Rezoning Transportation Analysis

Petition Number: 2020-145

General Location Identifier: Tax ID: 22313218

Date	Description
11-30-20	First Review (LJ)

RZ-2

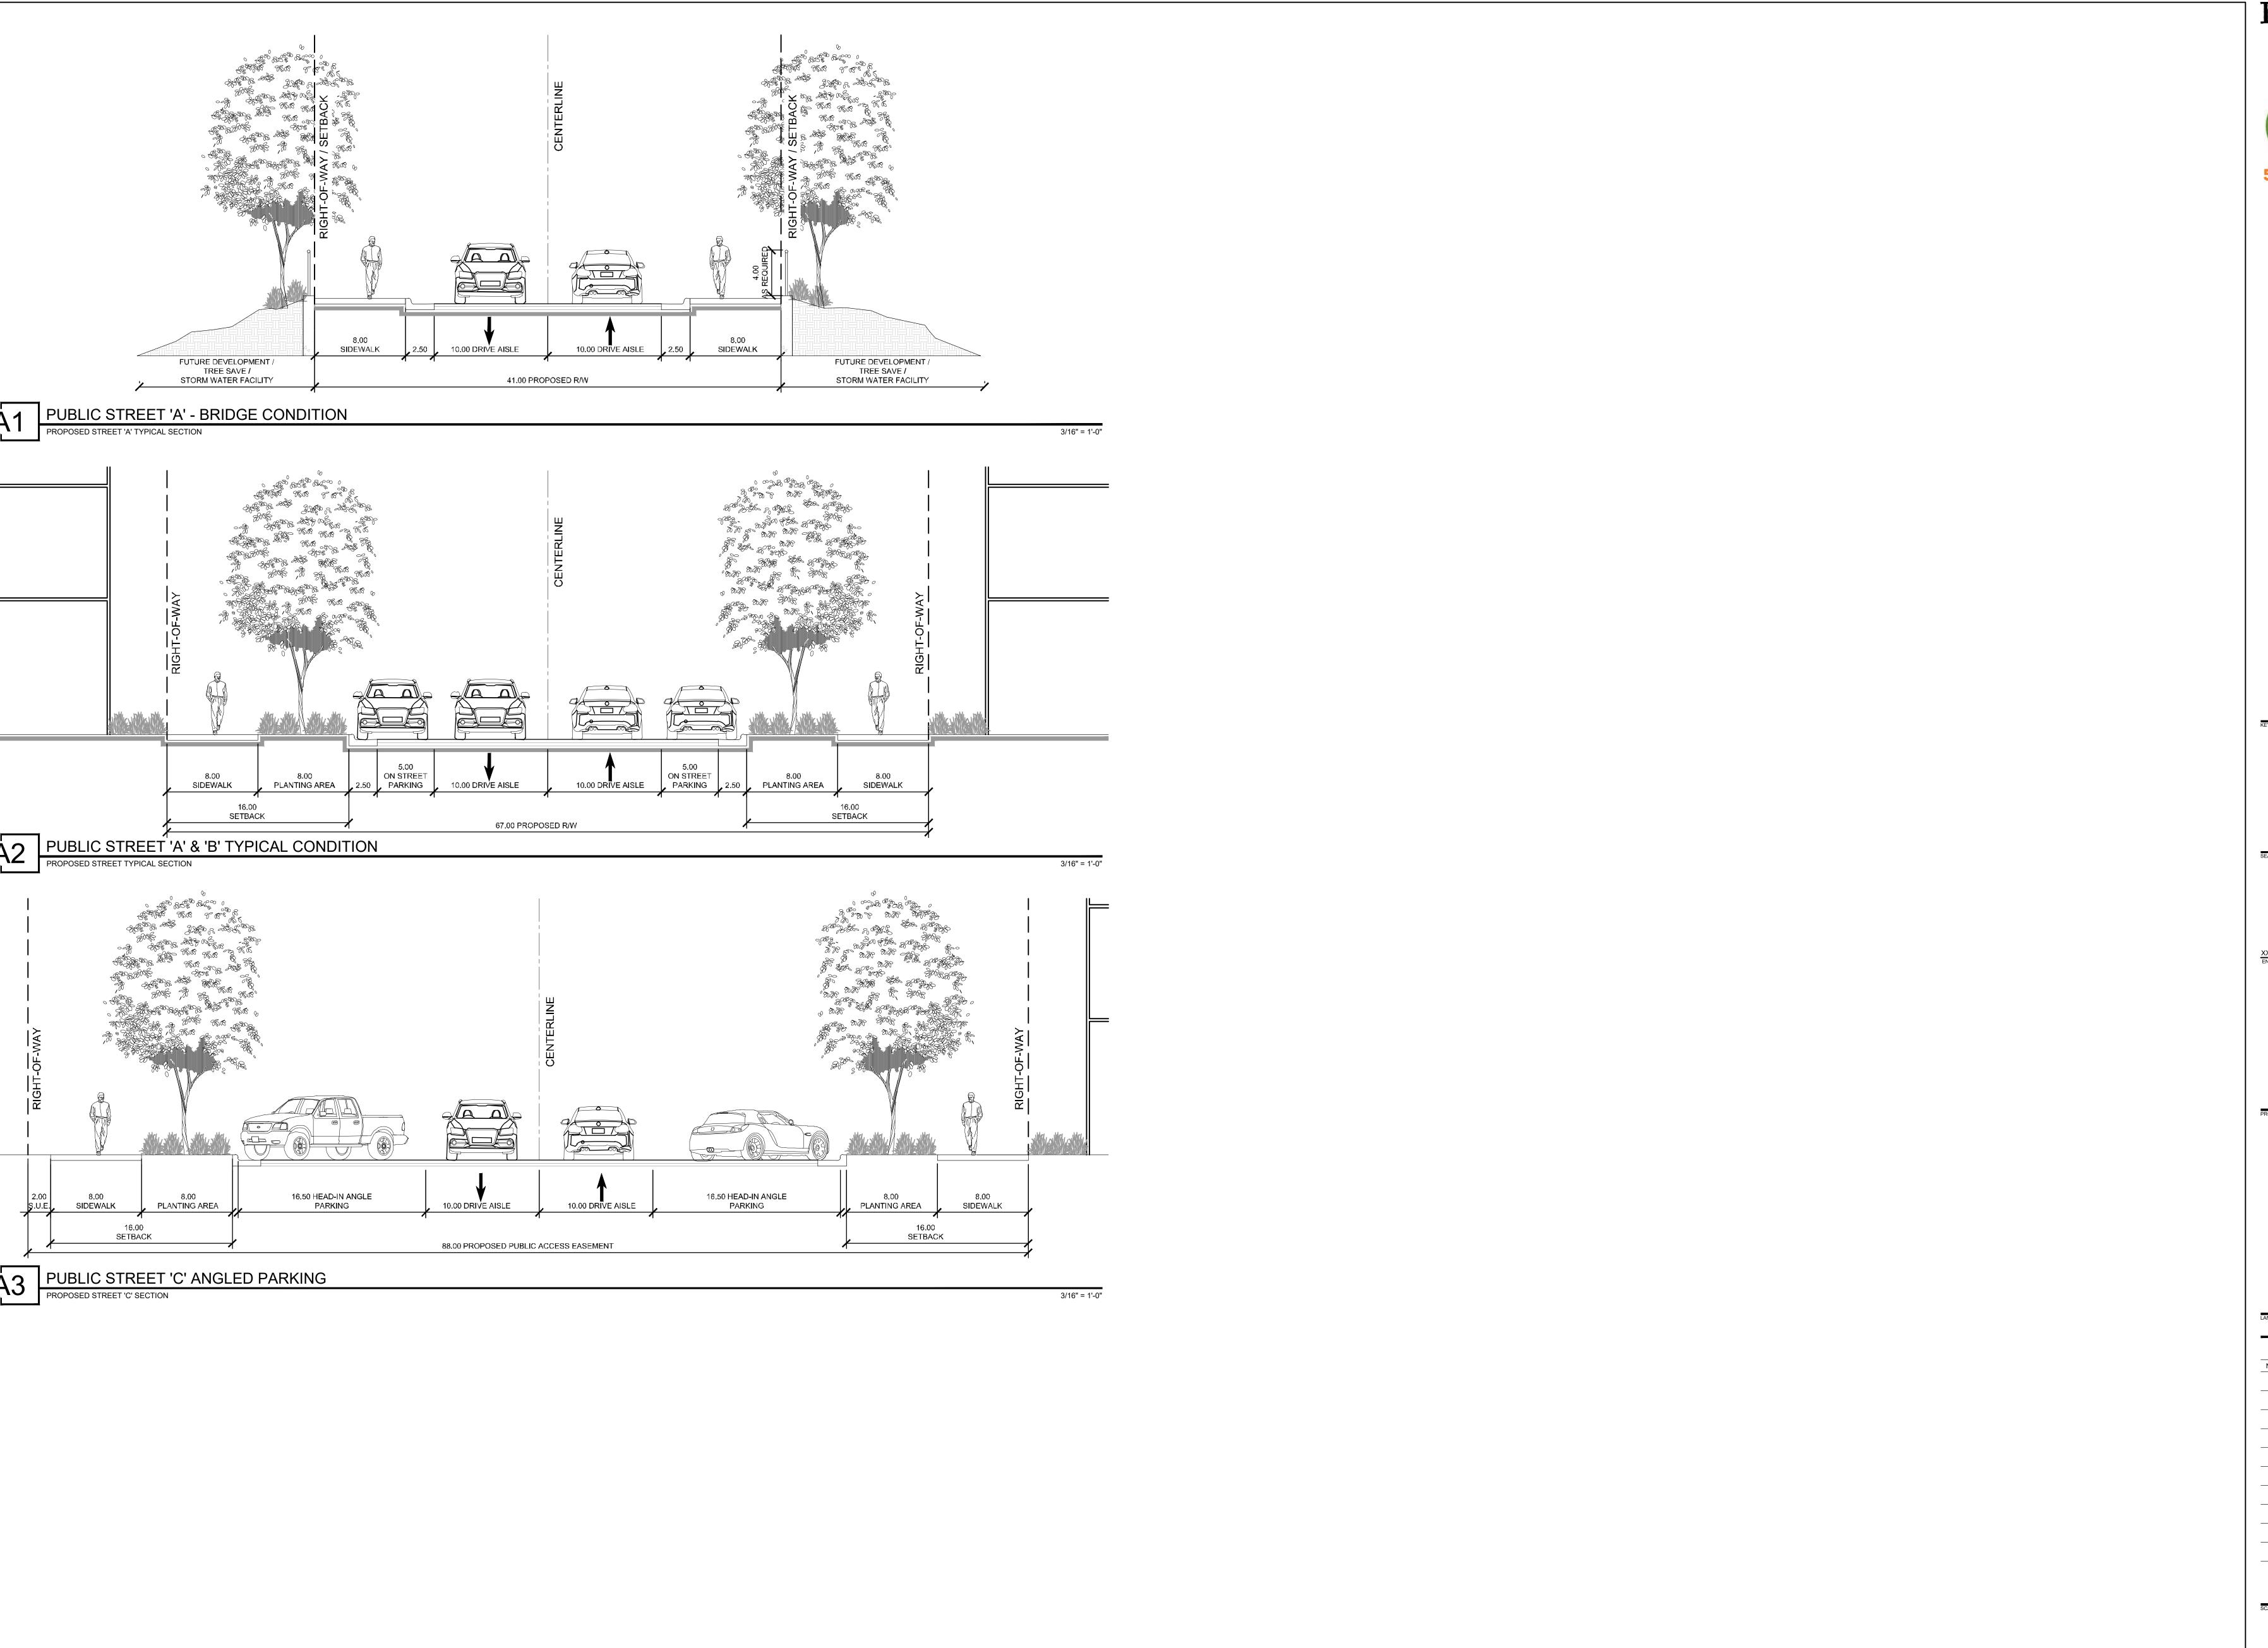
- Revise site plan and conditional note(s) to commit to dedicating 71' right-of-way for the Public Streets 'A' and 'B' per Chapter 20 and CLDSM, U-03A.19. The site plan shall label and dimension the right-of-way from road centerline.
- The Petitioner shall coordinate with NCDOT to obtain the required right-of-way width along Marvin Road and Johnston Road. Revise site plan and conditional note(s) to dedicate right-of-way from each road centerline.
- Revise site plans and conditional notes to commit to constructing an 8-foot planting strip, and 8-foot sidewalk along Public Roads 'A', 'B', and 'C' per Chapter 20, as the proposed dwelling units exceed 12

8. Add a site plan note(s) specifying dedication and fee simple conveyance of all rights-of-way to the City before the site's first building certificate of occupancy is issued is needed. CDOT requests rights-of-way set at 2' behind back of sidewalk where feasible.
9. Add a site plan note specifying that all transportation improvements will be approved and constructed before the site's first building certificate of occupancy is issued is needed. The petitioner may phase transportation improvements if said improvements and phasing are explicitly described in site plan notes.
